ORANGE DESIGN STUDIO.
ARCHITECTURAL PRACTICE

JUSTIFICATION DOCUMENT

54, WELLHOUSE LANE, MIRFIELD, WF14 09W

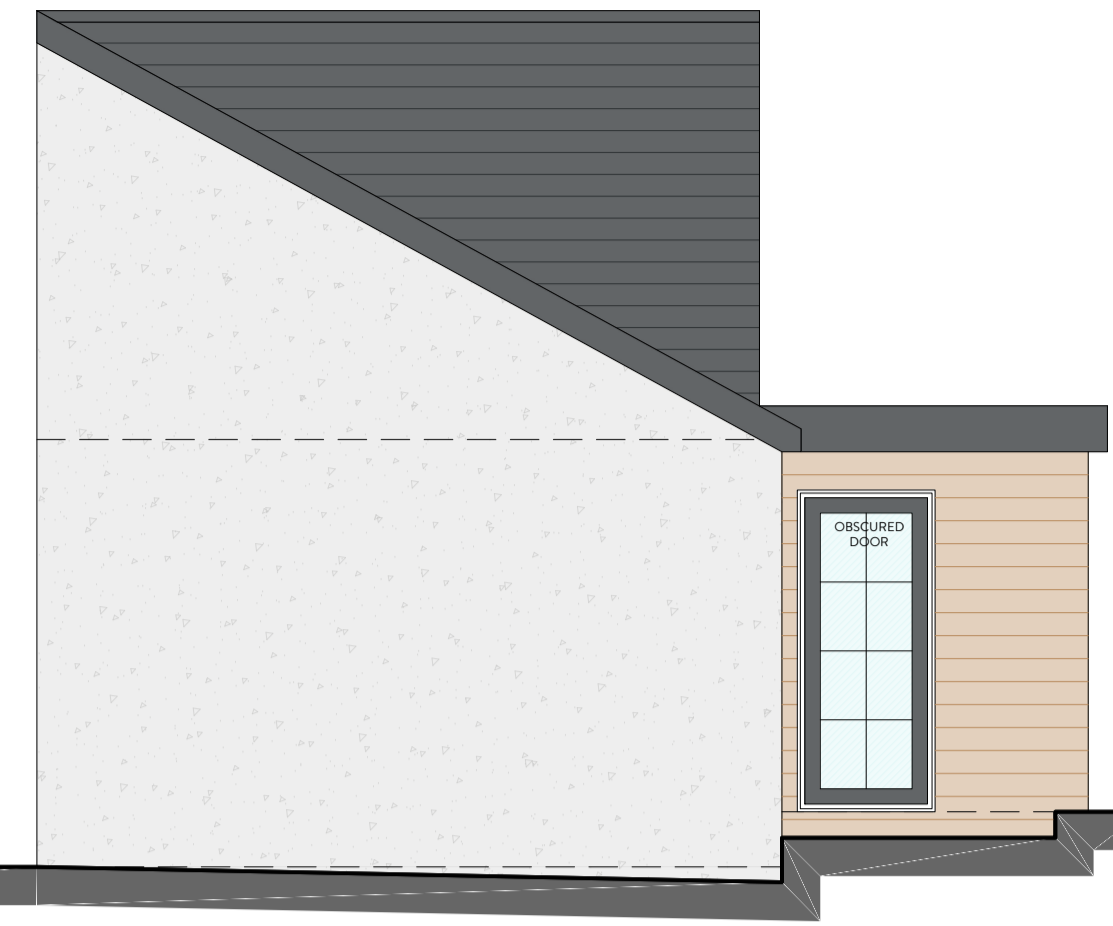
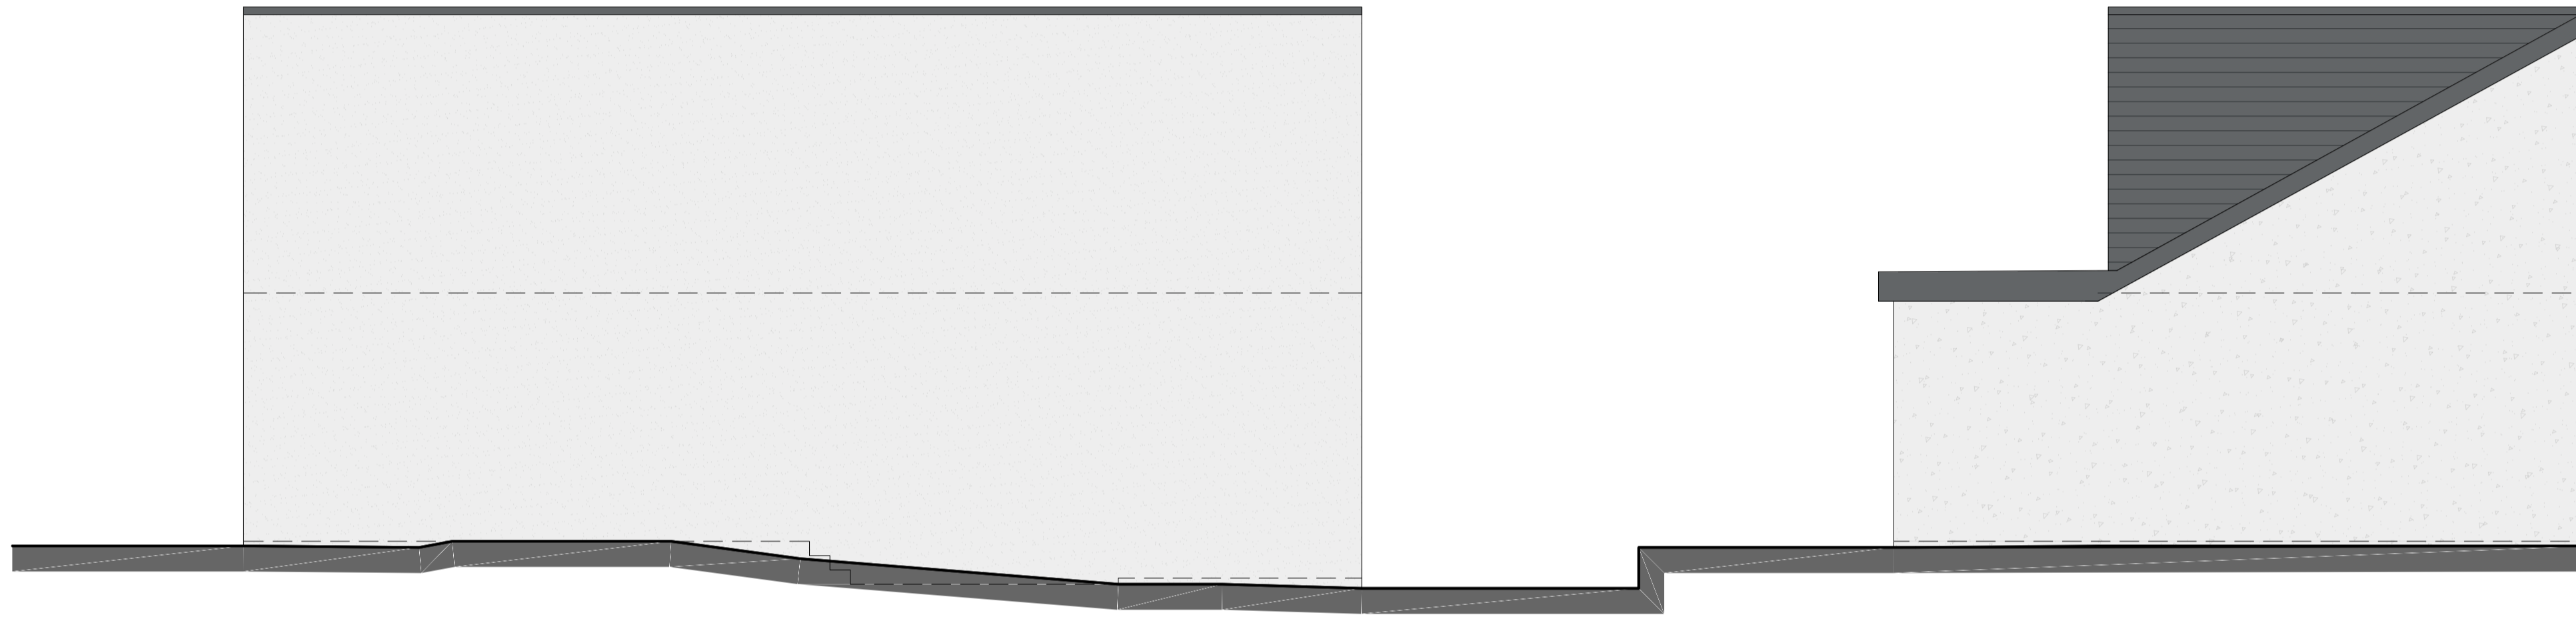
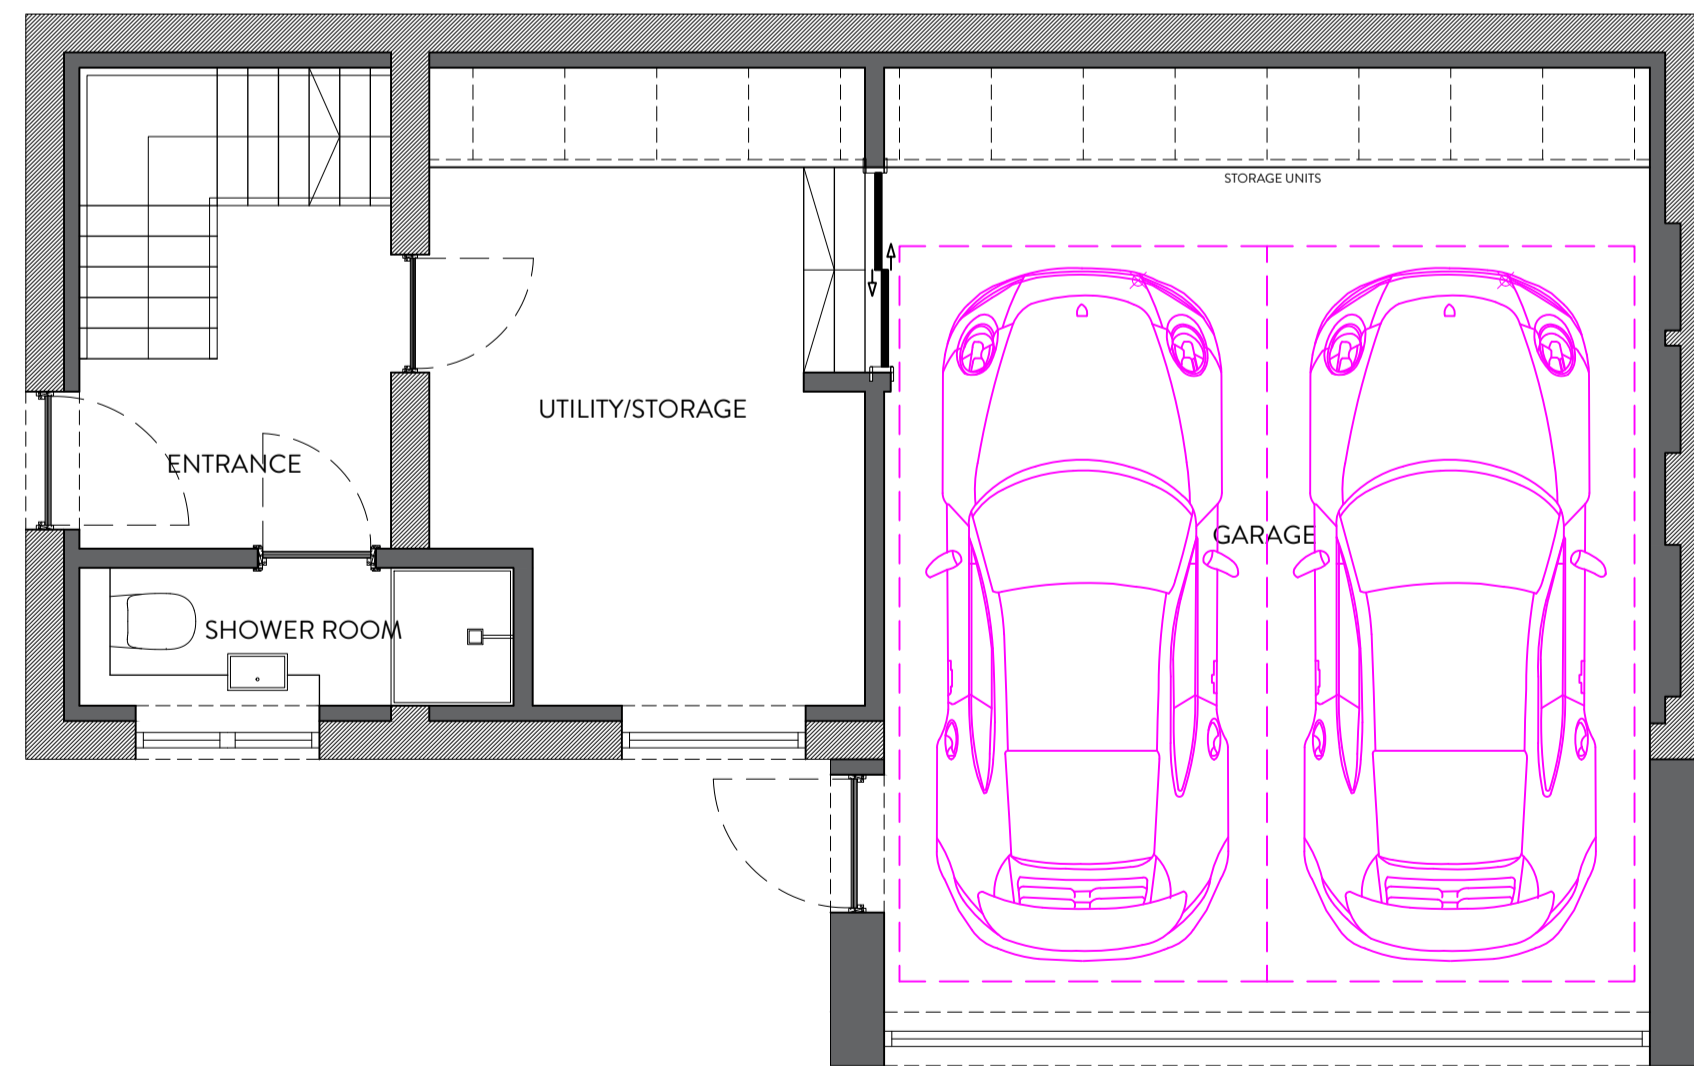
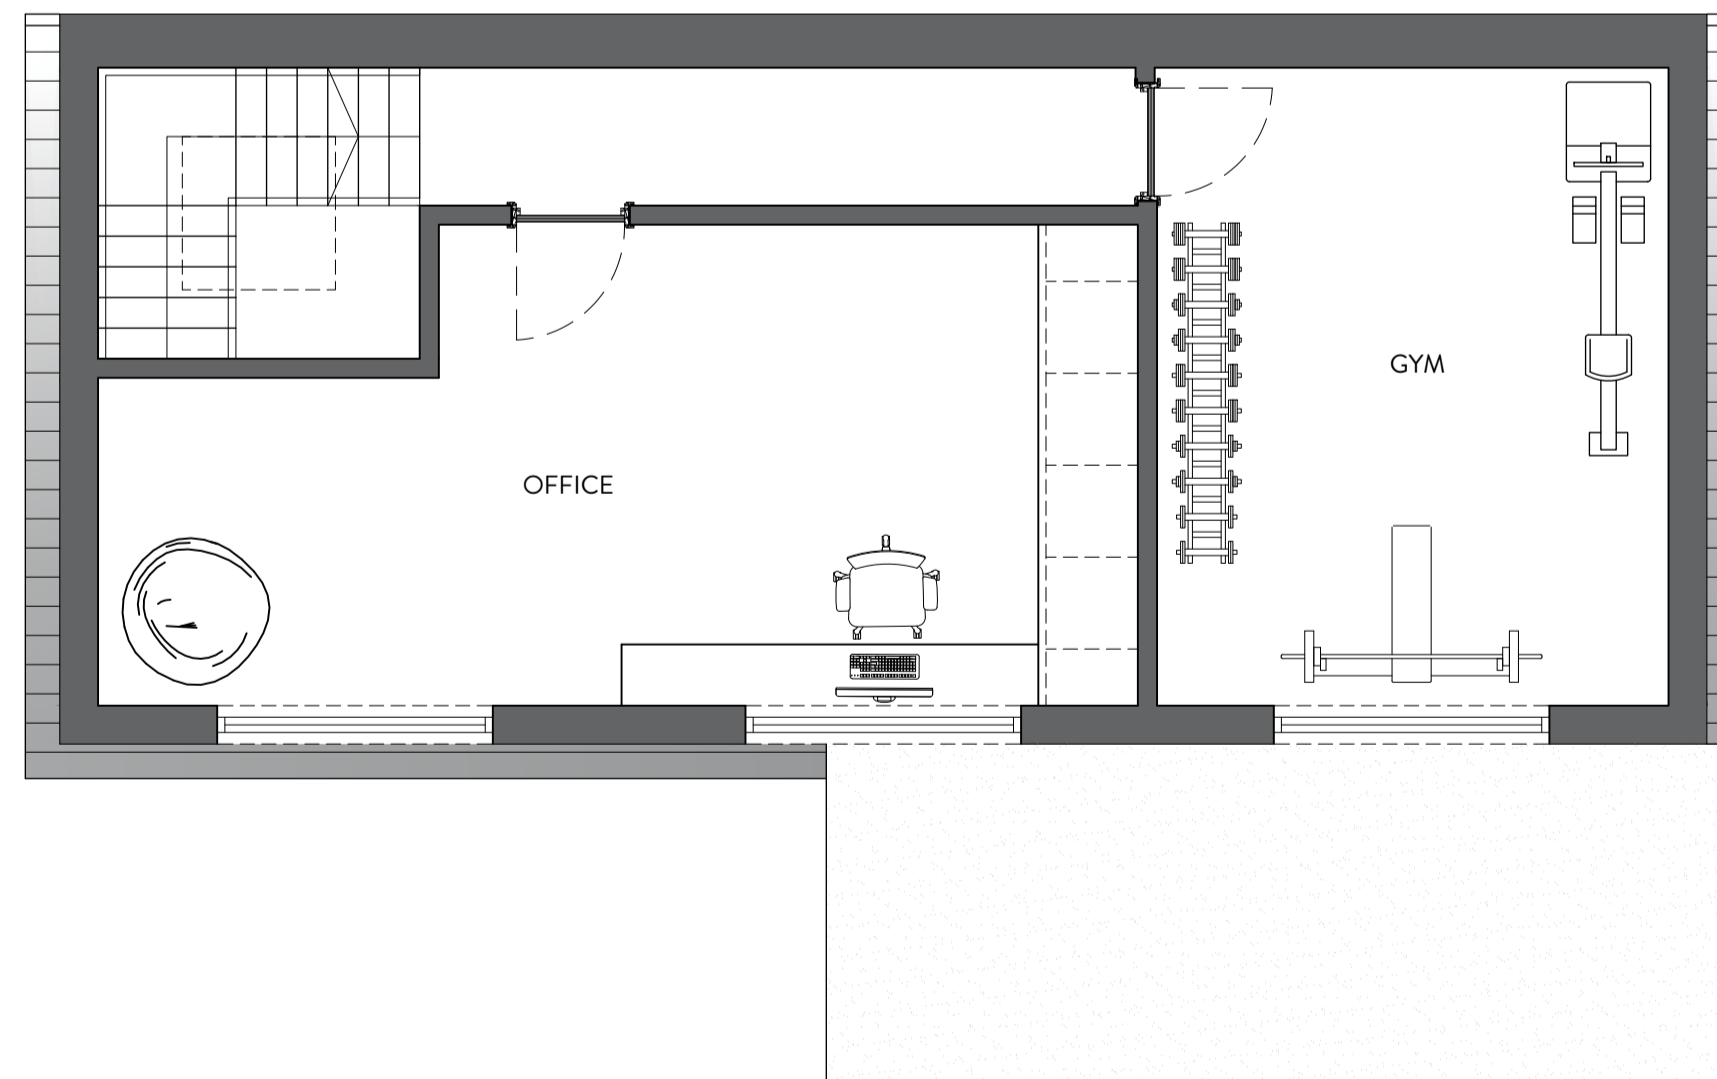
“The drawings suggest the proposals will have both visual and residential amenity impact on the existing neighbourhood.” – The proposed design carefully considers visual harmony of the neighborhood. The stone used on the proposed works will match the colour and texture of the existing house (54, Wellhouse Lane) and neighbouring properties, like 54A, Wellhouse Lane. This ensures that the. The detached garage will blend seamlessly into the surrounding context. The image attached below is an example of the stonework to be used on the proposed works, to match existing.

“My major concerns is the new height of this addition in the application of the plans submitted, as they do not specify any measurements and with misgivings do not address the over shadowing and light problems this new structure would create to immediate neighbor's at 6 Woodward Court, 54A Wellhouse Lane in the cul-de-sac with 54 Wellhouse Lane on this site and 56A Wellhouse Lane.” – Please refer to the shadow model below. This study compares the existing and the proposed, and it has been conducted to illustrate that the increase in roof height does not create a significant overshadowing issue or affect natural light on the neighbors at 6, Woodward Court, or 54A Wellhouse Lane. The distance between the detached garage block, combined with the thoughtful proposed roof height and form, to the neighboring properties is significantly enough to mitigate light and shadow overshadowing concerns.
